Tarrawonga Coal Mine LoM Mod. 7 Groundwater Assessment Peer Review

NSW Department of Planning
Industry and Environment

10 December 2020

TARRAWONGA COAL MINE
Indicative Modification
General Arrangement

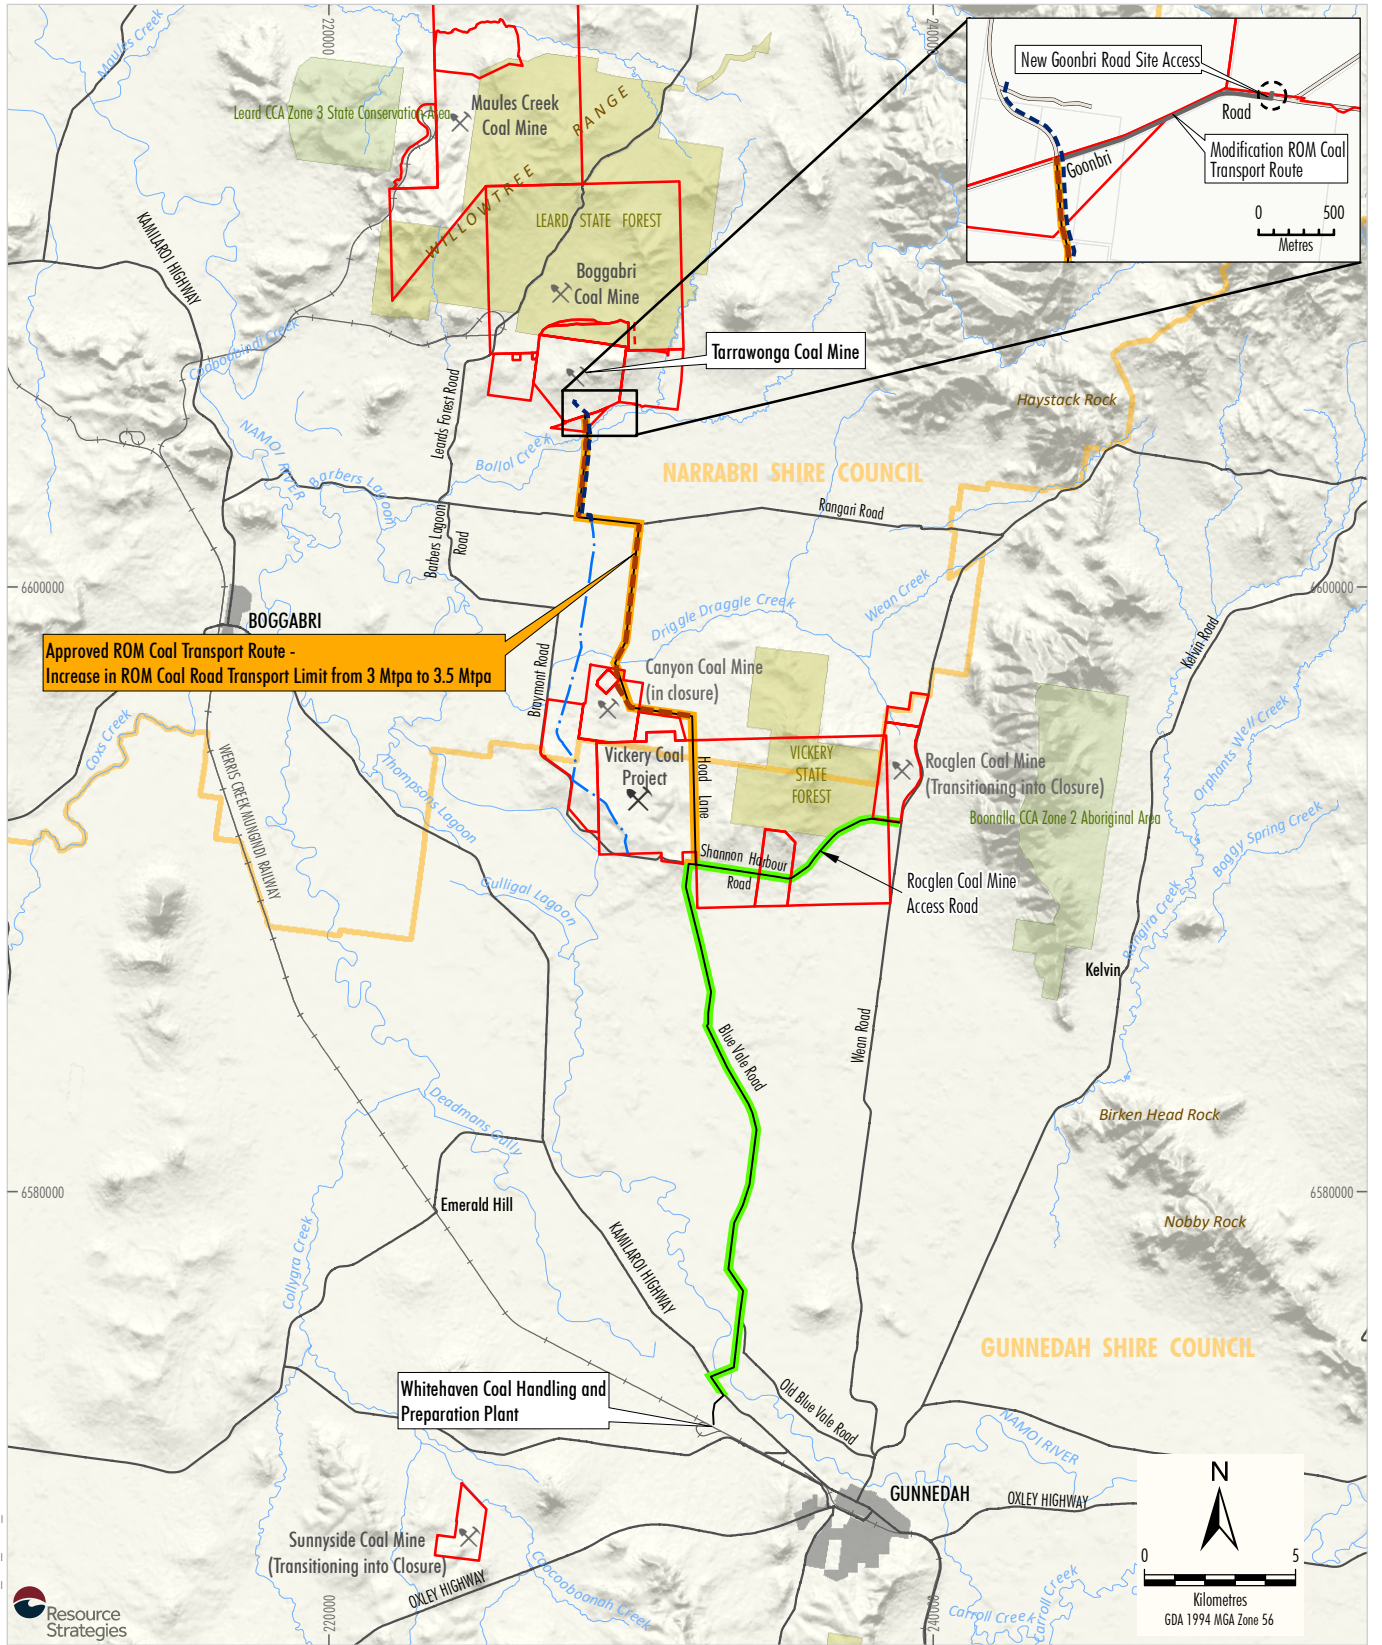
These statements appear to be in conflict with some key figures in the Modifications report that show the pit extent at its south-eastern corner. For example, Figure 3 below is based on Figure 5-2 of the Modification report, but is actually taken from page 5 of the submission by the People for the Plains. It shows that the pit crest extends up to the alignment of the NSW Government mapped alluvium (yellow line) along most of the eastern boundary. At its south-east corner, however, the pit crest aligns with the orange line that represents the alluvium mapped by SLR based on soil surveys and a topographical and geomorphological assessment (Attachment J of HydroSimulations 2019). In any case, it appears that the pit crest will extend up to the western-most alignment of the mapped alluvium, but would not actually ‘intercept’ the alluvium.

The problem is that the location of the pit crest is uncertain, based on the information presented. For example, Figure 3 below shows the south-east corner of the pit at about 150 metres from Goonbri Road. However, Figure 2-2 of the Modification report, shown below as Figure 4, shows this point at about 120 metres from Goonbri Road, and perhaps 80 metres from the nominal flood bund alignment (subject to detailed design). These

As the mapped alluvium is effectively unsaturated in this location, the pathway for leakage under the Mod 7 arrangement would be mainly via the fractured rock ‘basement’ of the Maules Creek Formation (Figure 5). This has arguably not been ignored in the Mod 7 reports, in that Hydrosimulations (2019) suggest on page 42 that the properties of the in situ ‘basement’ results in similar drawdown predictions under Mod 7 as for the approved case with a low permeability barrier under the flood bund (Figure 5).

Figure 1. Location of flood bund relative to pit extent and alluvial boundary

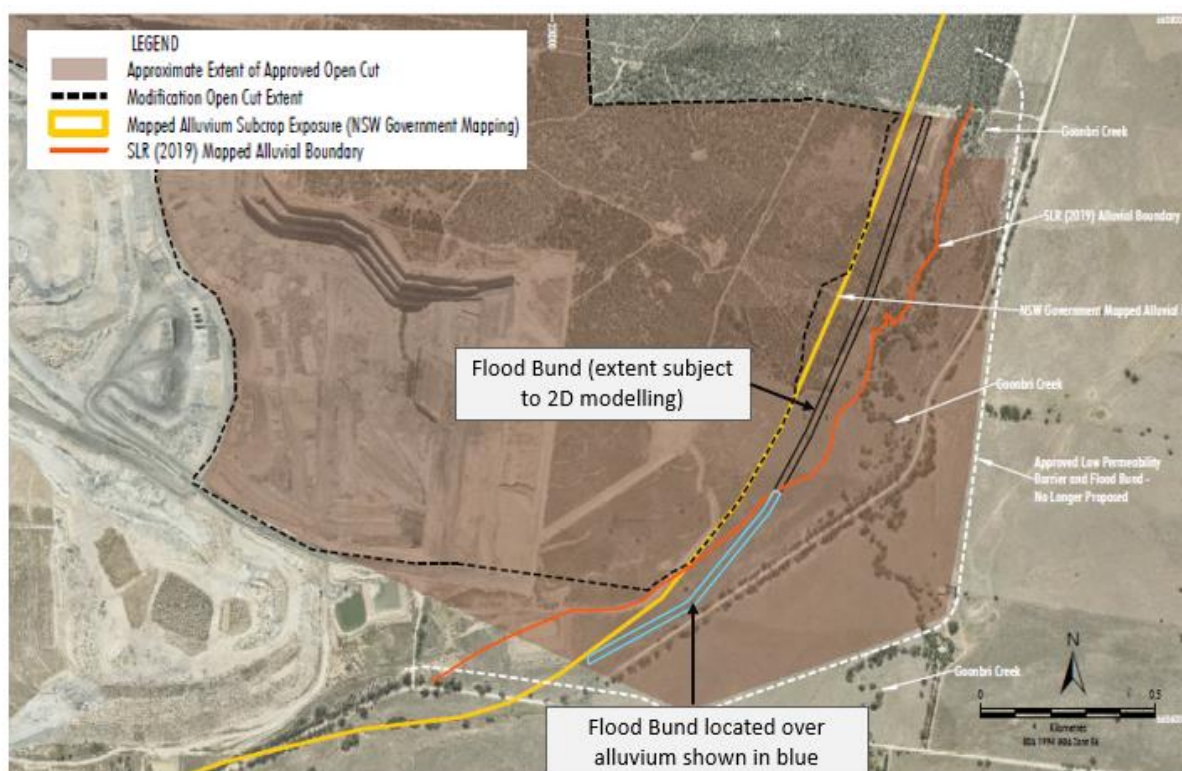
With reference to Figure 5, it is important to define the exact location of the pit crest and the flood bund and the mapped alluvium in order to assess whether or not there may be the potential for leakage towards the pit and/or post-mining void via the alluvium and/or fractured rock basement due to flood inundation events, as several submissions have commented (eg. DPIE Water and People for the Plains).

- Firstly, based on statements in the Modifications report, it is assumed that the pit crest is aligned with the western-most mapped alluvium, and the flood bund will actually be located between the pit crest and Goonbri Road, as shown generally in Figure 4. The soil mapping shows that the alluvium is dry at its mapped extent (SLR 2019), so there is no flow path from saturated alluvium towards the pit or final void under normal conditions. This means that the source of leakage would have to be from any floodwater that might pond against the flood bund, which is some 100-200 metres from the pit crest generally, except near the south-east corner of the crest where it may be around 80 metres.

Figure 2. Predicted flood extents [after HEC (2019), Figures 29 & 30]

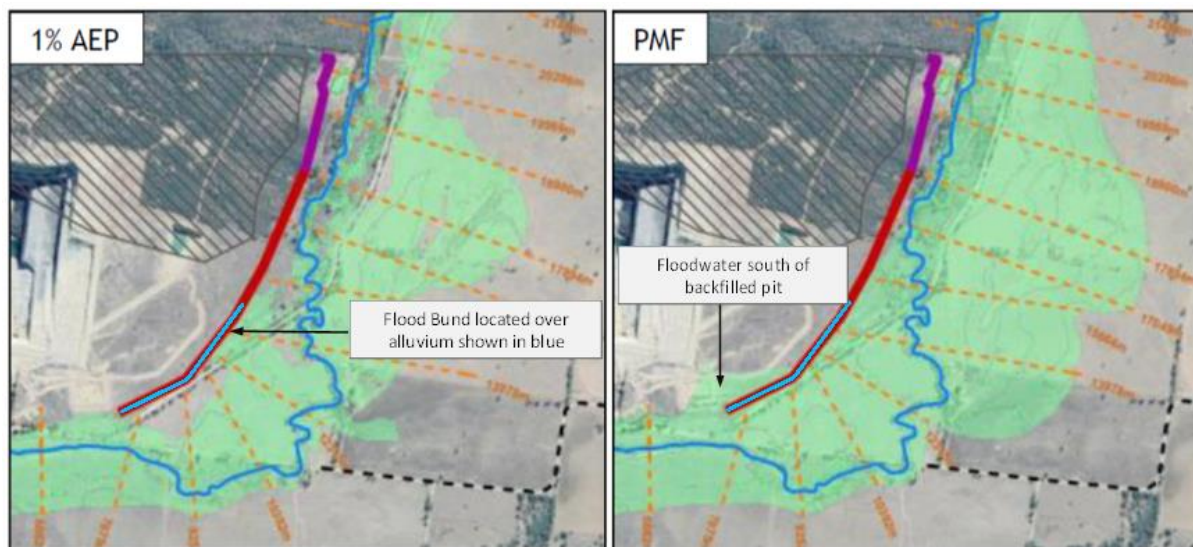
- Under those conditions, the 2D flood modelling prediction for the 1% annual exceedance probability (AEP) (‘1 in 100 year’ flood event), shows some ponding against the flood bund (Figure 6, after HEC 2019, Figure 29). The flooding assessment indicates that the ground level adjacent to the final void is at least 6 metres higher than the predicted flood level, which itself is lower than the flood bund crest by about 1 metre (HEC 2019, Table 33). Although the flooding assessment does not indicate the duration of such ponding, it does indicate that the 1% AEP critical storm duration is 2-3 hours, which implies that the flooding

duration would likely be in the order of days. This indicates little opportunity or potential for leakage from a 1% AEP flood event to adequately saturate the subsurface units and convey substantial volumes towards the pit or void. It is also noted that the probability of occurrence of a 1% AEP flood within the 10 year LoM period to 2030 is low at about 9.5%, while within a 100 year period it is about 63%, rising to about 85% within 200 years and 95% in a 300 year period (ie. it is likely during the closure period).

- Similarly, while the 2D flood modelling prediction of the larger event of the probable maximum flood (PMF; there is no established method of estimating its probability) shows some inundation on the western side of the indicative flood bund at its southern end (Figure 6), roadworks and pit crest bunding should apply adequate controls operationally to retain the floodwaters, and similarly for the post-mining landform.
